# CITY OF ALBUQUERQUE

**Re: WAREHOUSE ON ASPEN**  
**300 Aspen Avenue NW**  
**Approval of Temporary Certificate of Occupancy (C.O.)**  
**Engineer's Stamp dated 04/04/2003 (J-14/D145)**  
**Certification dated 09/23/2005**

REFERENCE: Grading and Drainage Plan for Tract A-2, located at 300 Aspen Avenue NW, (J14-D145)

SHEET TITLE: DRAINAGE AND GRADING PLAN

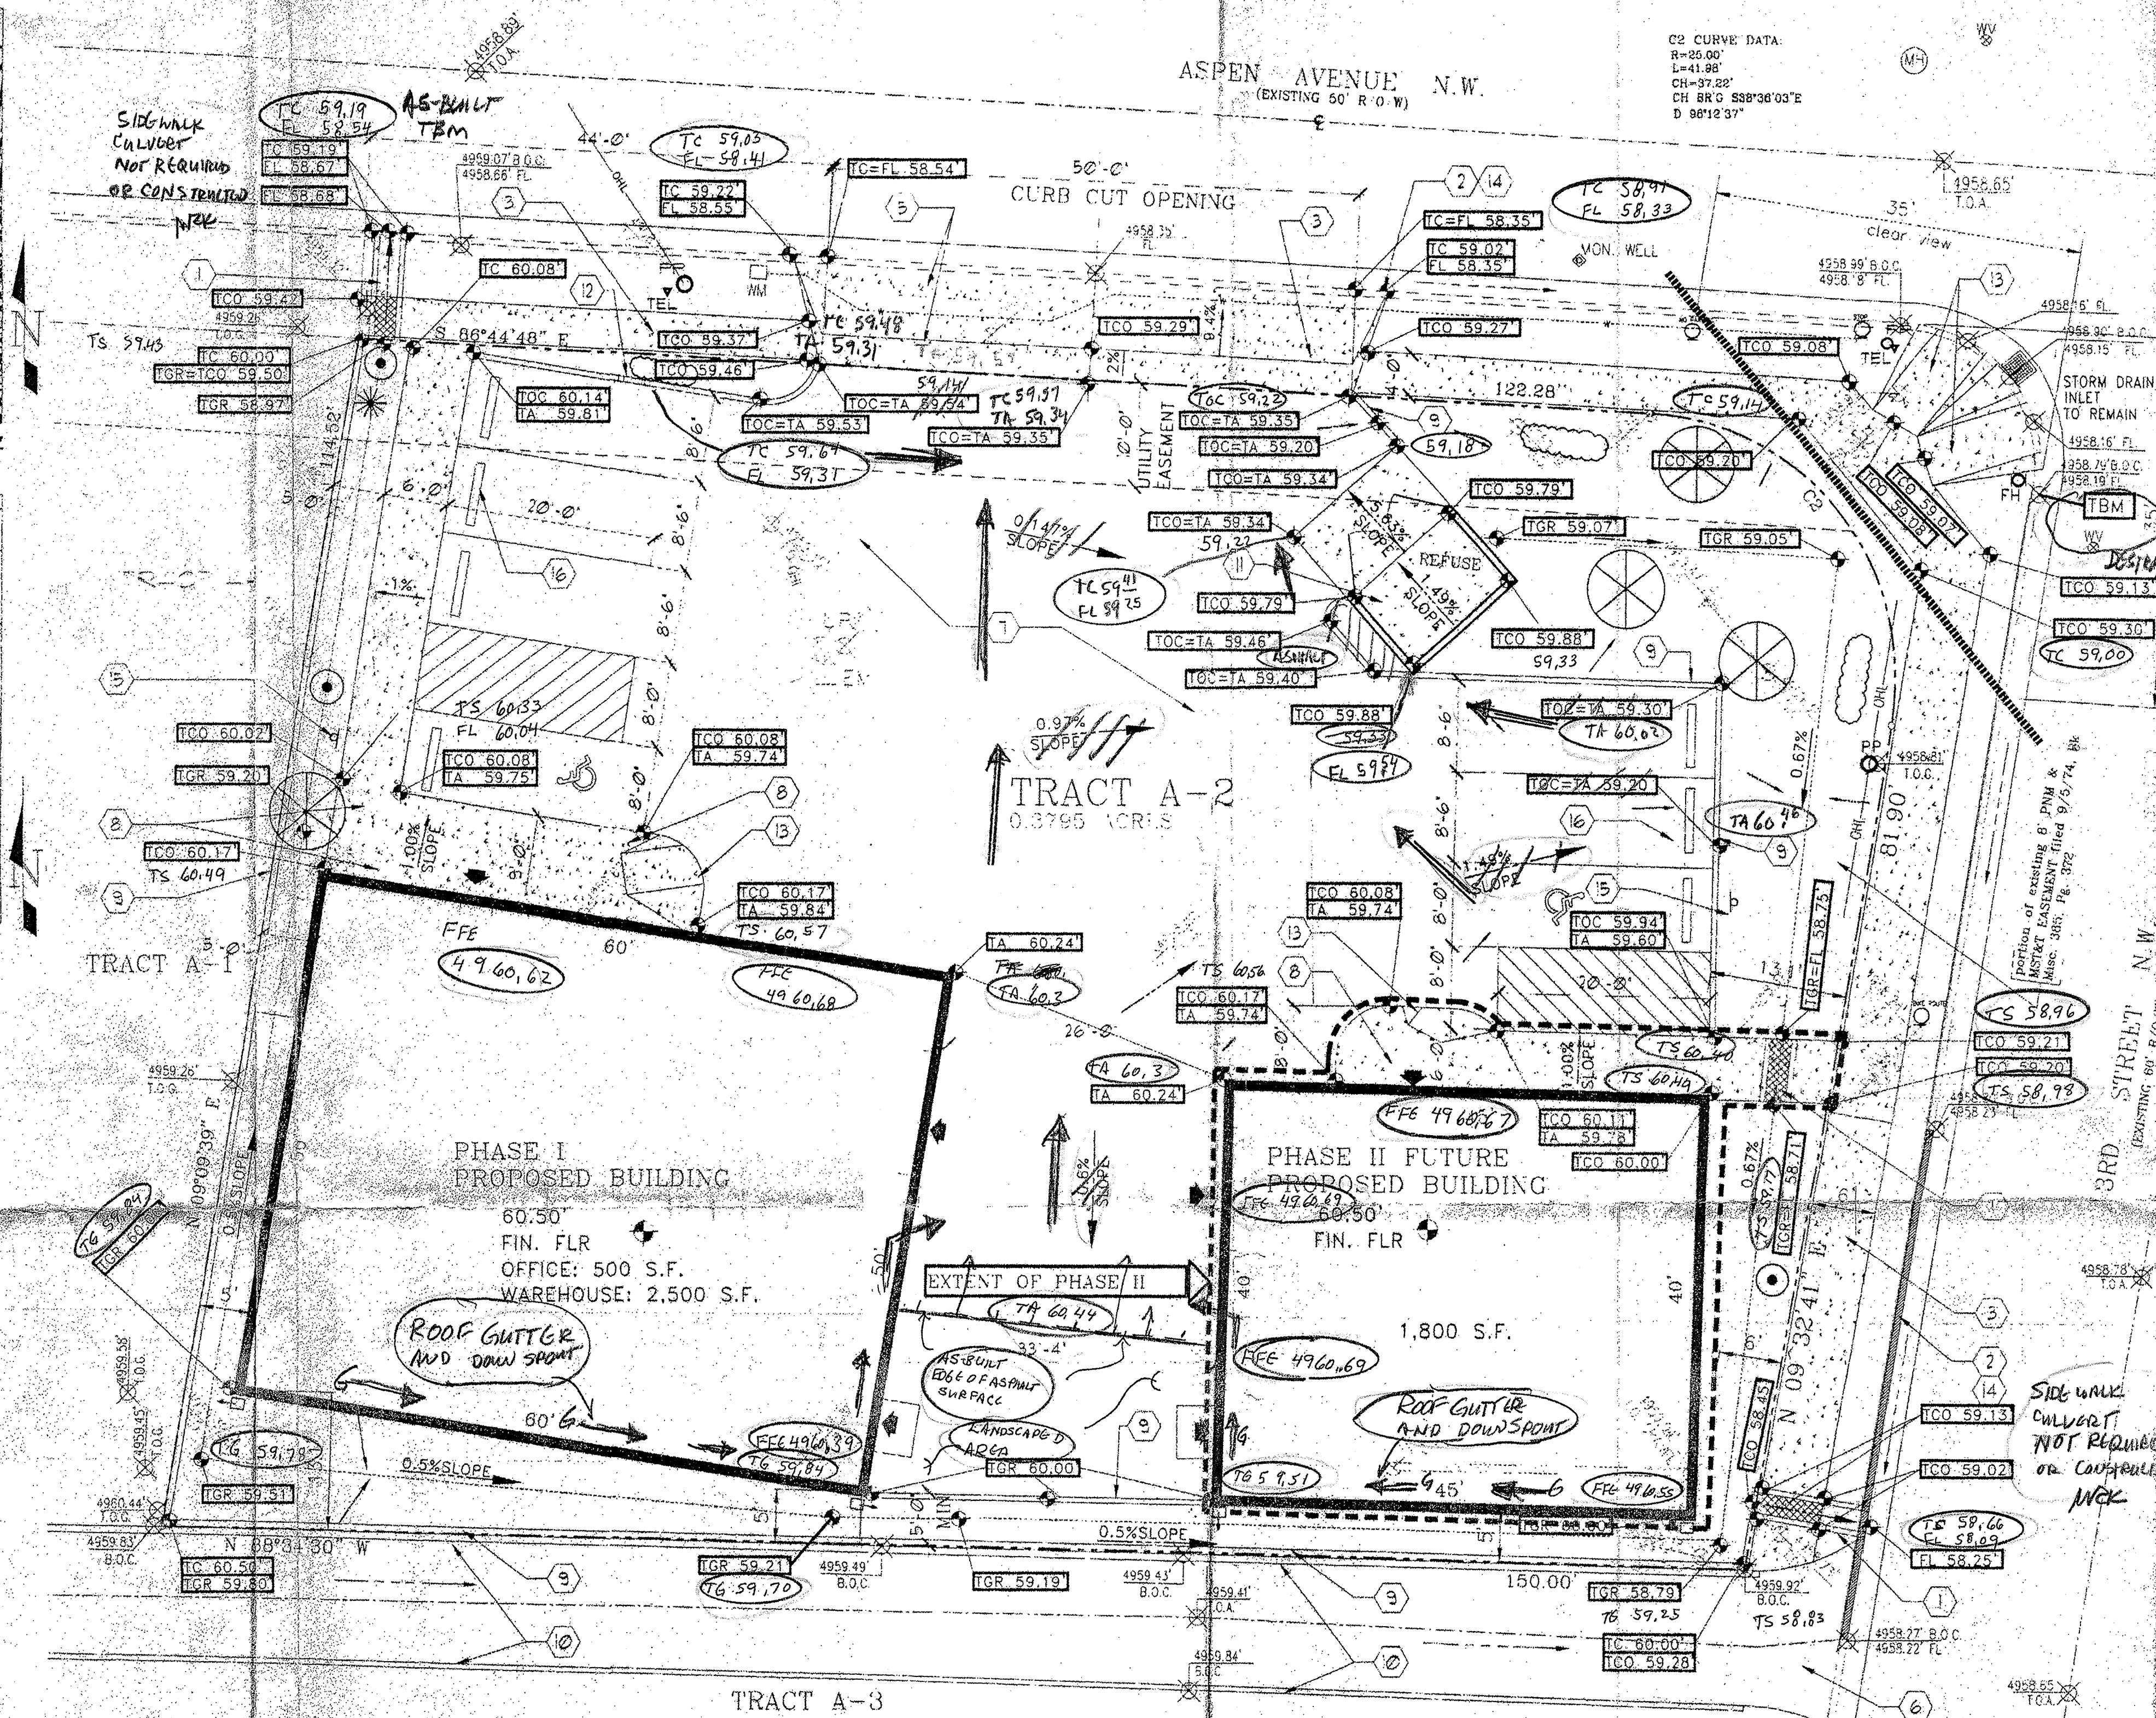
MINOR DEFICIENCIES ARE THAT THE CURB ALONG THE SOUTH LOT LINE AND THE SIDEWALK CULVERTS AT THE SOUTHEAST CORNER AND THE NORTHWEST CORNER HAVE NOT BEEN CONSTRUCTED. LISTED BELOW ARE CHANGES TO THE PLAN WHICH WILL CORRECT THE DEFICIENCIES:

- A. THE ONLY RUNOFF FROM IMPERVIOUS SURFACES THAT FLOWS TO THE SOUTH PART OF THE PROPERTY IS FROM THE SOUTH HALF OF THE PITCHED ROOF ON THE TWO BUILDINGS. I RECOMMEND THAT A GUTTER AND DOWN SPOUT BE INSTALLED ON THE BUILDINGS, WITH THE DOWN SPOUT DIRECTING THE ROOF RUNOFF TO THE ASPHALT DRIVEWAY.

- B. A TREATED TIMBER CURB SHOULD BE SUBSTITUTED FOR THE CONCRETE HEADER WALL THAT WAS APPROVED ALONG THE SOUTH PROPERTY LINE. THE TREATED TIMBER (RAILROAD TIES ARE SATISFACTORY) SHOULD BE 6" BY 6", OR LARGER, TWO OR MORE COURSES, WITH AN OVERLAP STACKING OF THE COURSES. THE TOP OF THE CURB SHOULD BE TO THE ELEVATION SPECIFIED ON THE APPROVED PLAN. THE REASON FOR USING TIMBER IS THAT CONCRETE IS PRESENTLY IN SHORT SUPPLY, AND THE TIMBER CURB WILL DO THE SAME FUNCTION, WHICH IS TO PREVENT DIRECT RUNOFF ONTO THE ADJACENT PROPERTY. THE NEW CHAIN LINK FENCE ALONG THE PROPERTY LINE WILL PROVIDE A STABLE BACKING FOR THE TIMBERS.

- C. THERE WILL BE NO NEED FOR EITHER OF THE SIDEWALK CULVERTS IF THE ROOF RUNOFF IS DIRECTED TO THE NORTH OVER THE ASPHALT SURFACED DRIVEWAY. THE ONLY RUNOFF TO THE CULVERTS THEN WOULD BE THE DIRECT PRECIPITATION THAT FALLS ONTO THE LANDSCAPED PART OF THE PROPERTY. THIS RUNOFF CAN BE RETAINED AND PERCOLATED INTO THE GROUND. THE LANDSCAPED PORTIONS SHOULD BE COARSE GRAVEL OVER A PERVIOUS WEED BARRIER, OR RUNOFF CAN BE DIRECTED TO THE TREE AND BUSH PLANTINGS.
